Add PCD File PPR-22-044

<p>FOX RUN SUBSTATION SITE PLAN</p> <p>TRI-STATE GENERATION & TRANSMISSION ASSOCIATION, INCORPORATED</p> <p>UPDATED BY: KENJUL 4/12/2022 5:24 AM PATH: T:\Projects\Fox Run Substation\90% Cvt Dwg\Site Plan.dwg</p>		<p>Revision</p> <p>Appd.</p> <p>Date</p> <p>No.</p>	<p>Reference Drawings</p> <p>Mgr.</p> <p>Dwg. No.</p> <p>M.F.</p>
7			
6			
5			
4			
3			
2			
1

SITE PLAN

LANDSCAPE PLAN

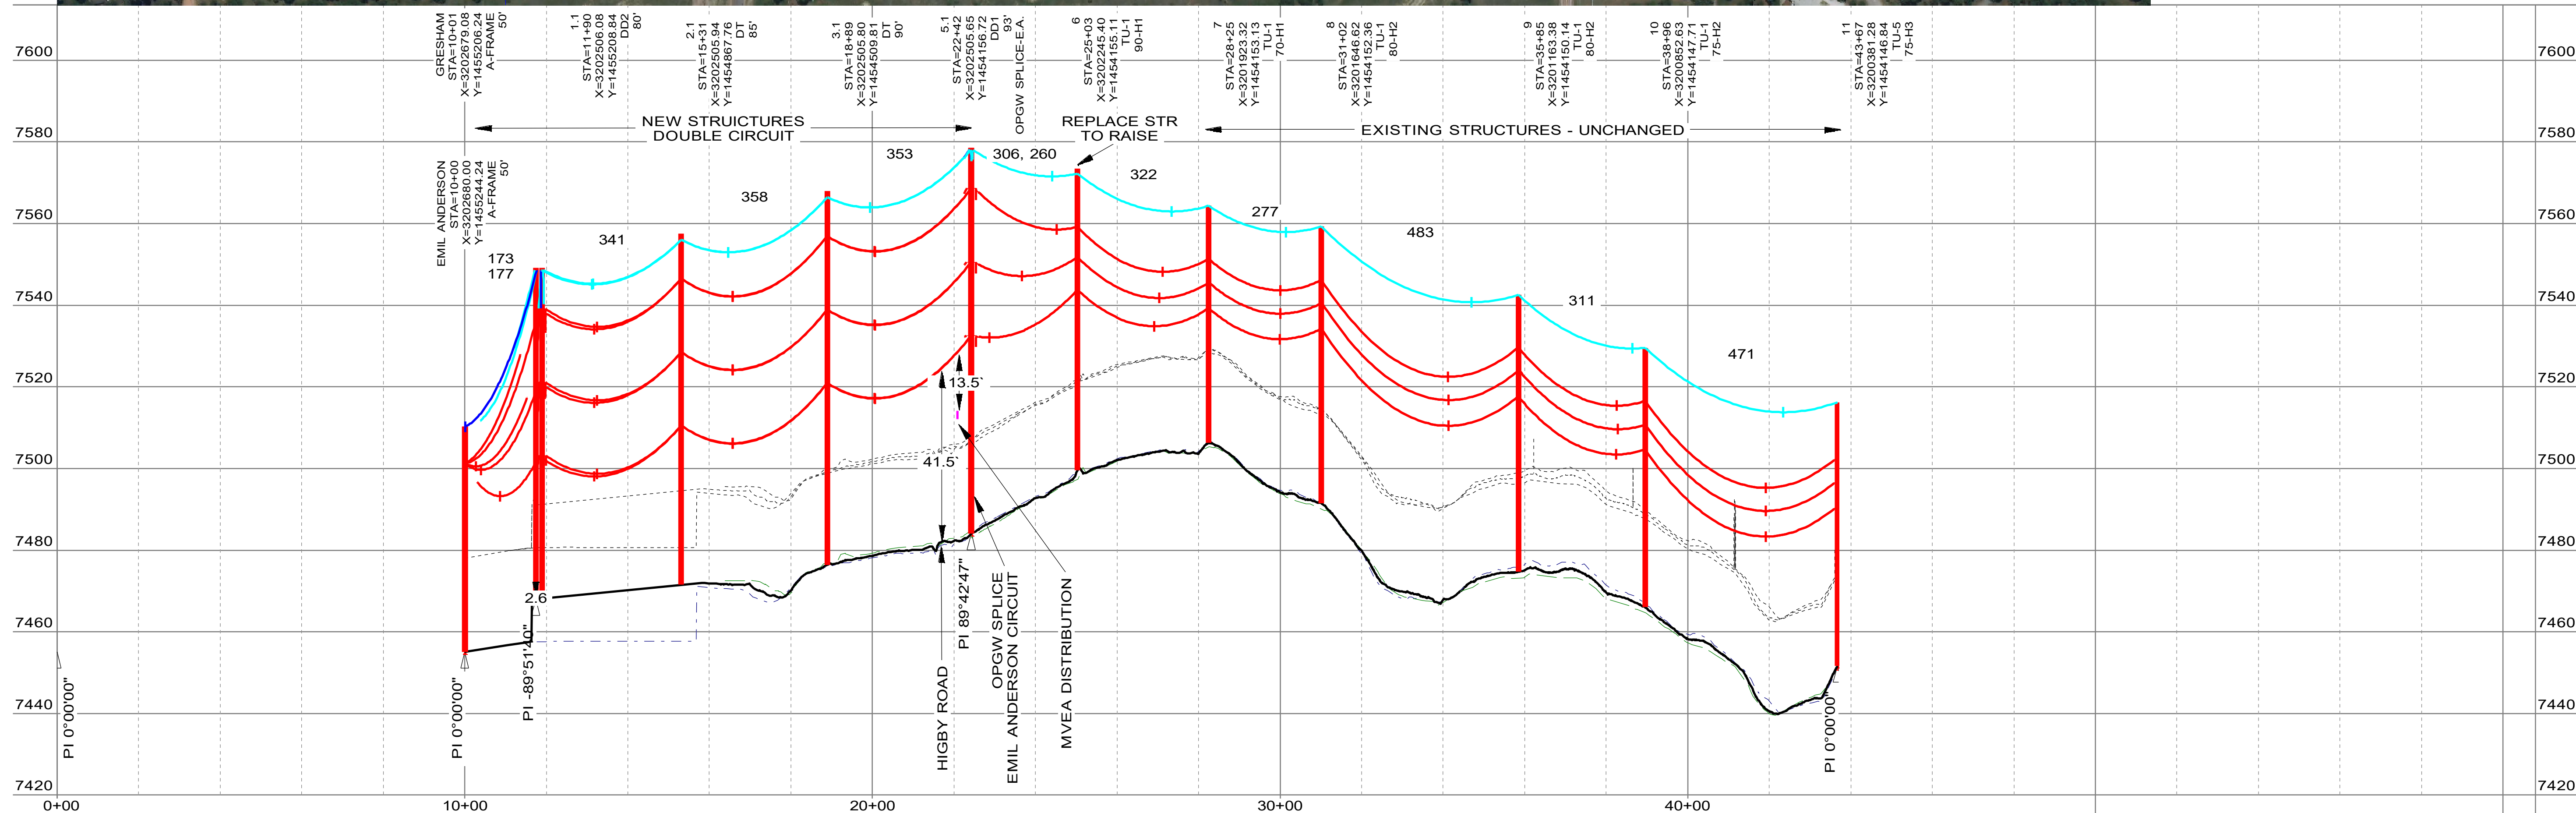
Add undisturbed native areas for total lot area to match project boundary

Lot is 652,806sqft
